Planning application no.: 3.24.531

Location: 15 Copperfield Close, Clitheroe

Proposal: Proposed conversion of existing integral garage to study and wc, construction of port to front and provision of additional hardstanding to create extra parking

Client: Mr & Mrs Capstick		
Project: Proposed Alterations 15 Copperfield Close Clitheroe		
Dwg title: Proposed Site Plan		
Scale @ A4: 1:200	Date: 24.06.24	Drawn by: PD
Drawing no. 1615 - 202	Rev. -

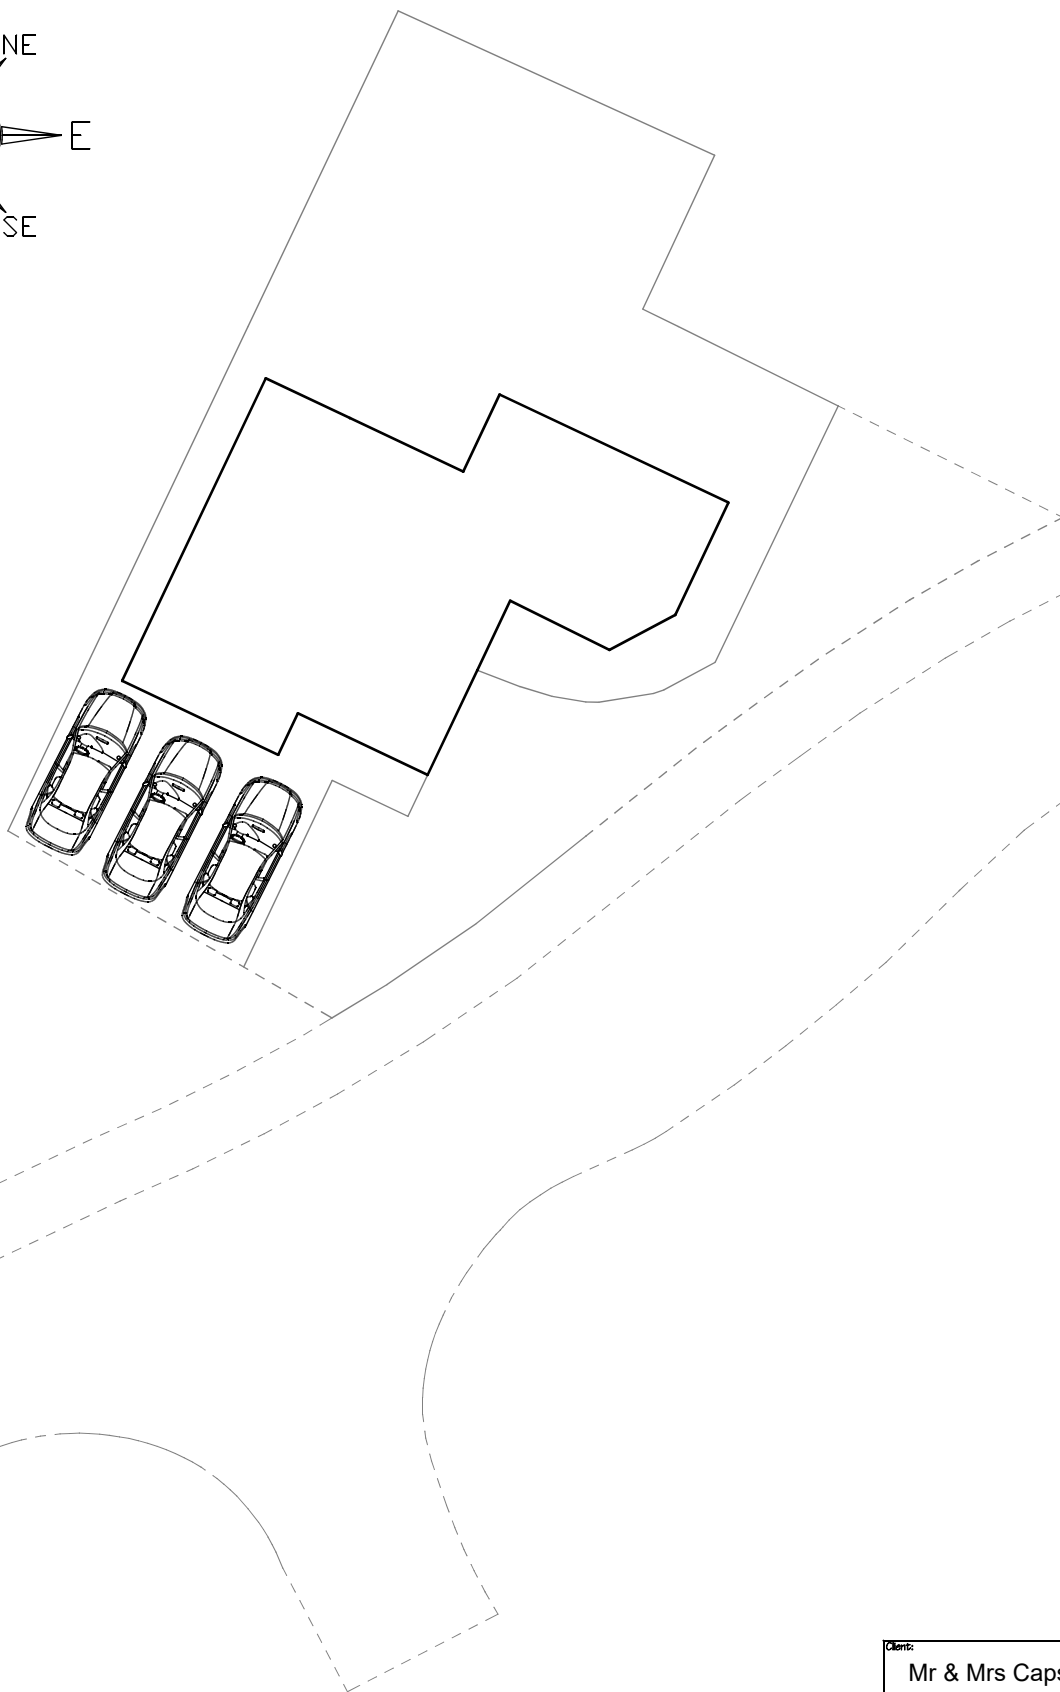
There is a loss of a garage with this proposal and a proposed change to the parking arrangements in order to create an extra parking space on the drive. There is no highway objection providing the following condition is noted.

The parking areas must be constructed of a bound porous material and created before first occupation up until the lifetime of the dwelling existing in its proposed state. Reason: To ensure that satisfactory parking is provided before the dwelling hereby permitted becomes operative.
